NSW National Parks and Wildlife Service

Your ref: SSI-77018220
Our ref: DOC26/203372

Thank you for notifying the NSW National Parks and Wildlife Service (NPWS) of the exhibition of the Environmental Impact Statement (EIS) for the proposed Lake Lyell Pumped Hydro Energy Storage (SSI-77018220). I understand this development has been declared to be critical state significant infrastructure, and I appreciate the extension of time in which to provide this advice.

Detailed NPWS comments on Lake Lyell EIS

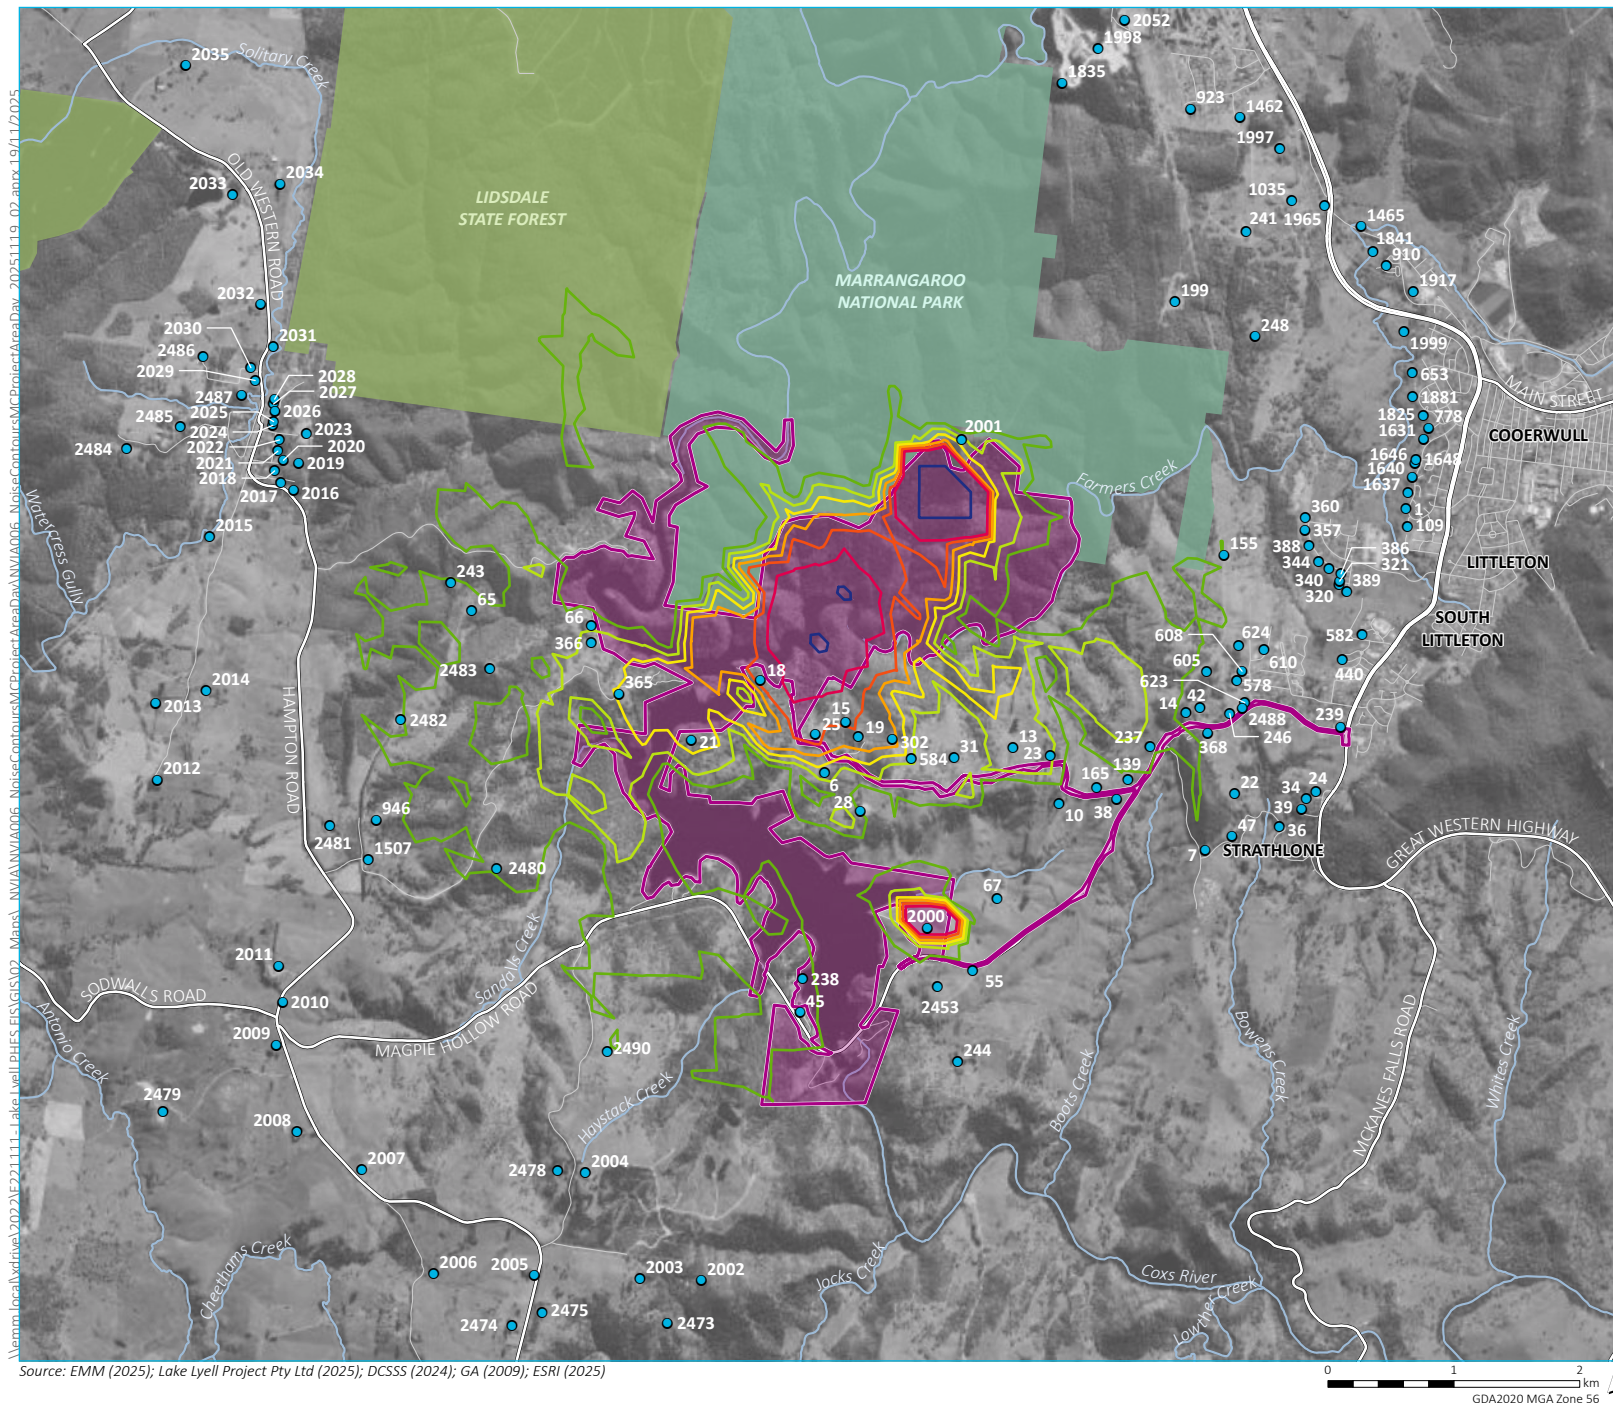
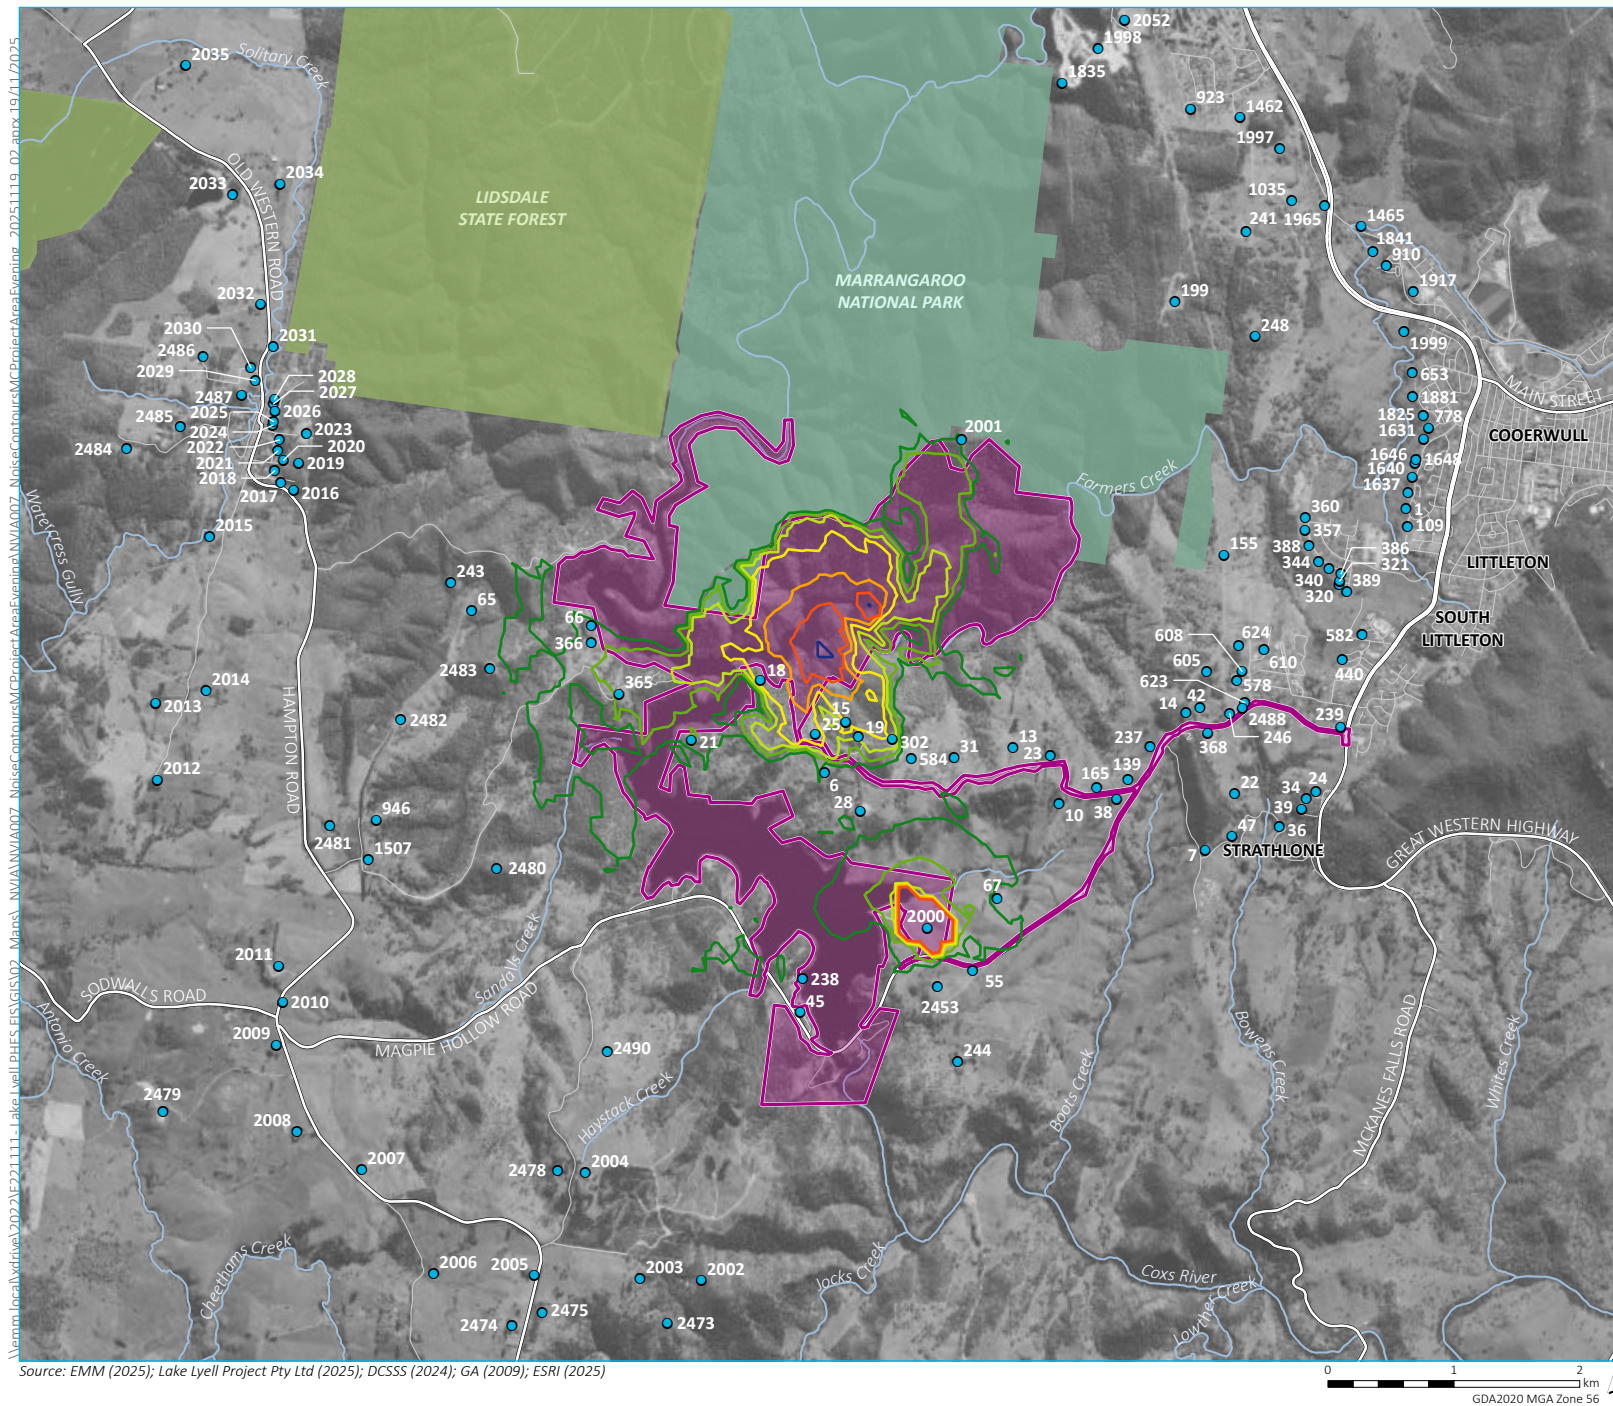
Figure 6.7 in Appendix R identifies that, during the 'morning shoulder' of the main construction works (from 6am to 7am, Monday to Saturday), large areas of park will experience noise levels >40dB(A), including the Marrangaroo campground. This is above the sleep disturbance screening criteria. The scientific literature identifies that impacts on fauna behaviour (movements, avoidance and vocalisation) also start to occur at levels more than 40dB(A).

During the 'morning shoulder', Figure 6.7 identifies that small areas along the boundary of the park will be >65dB(A) which is more than 5 times the intensity of noise compared to the 50dBA

set under the NfPI for 'areas reserved for passive recreation'. Sleep in these areas will be impossible. While not yet at the level of being 'annoyingly loud', conversation is difficult at levels of noise above 65dB(A).

NPWS advises that the EIS is misleading in its assertion that that noise levels will not exceed the NfPI's 'adopted criteria for passive recreation'. The noise levels predicted to be experienced in parts of the park will have a measurable impact on fauna in the park and the amenity of park visitors. Further, in NPWS's opinion, these noise impacts have not been adequately assessed or mitigated.

- Additional assessment to recognise and quantify the noise impacts on the park's fauna and the amenity of visitors to the park, including the unacceptable disturbance to campers' sleeping before 7am during the main construction works.
- A modification to the proposed construction hours (Table 3.4 of the EIS) to exclude construction and blasting on Saturdays, Sundays or public holidays to avoid causing unacceptable noise levels during periods of peak visitation to the park.
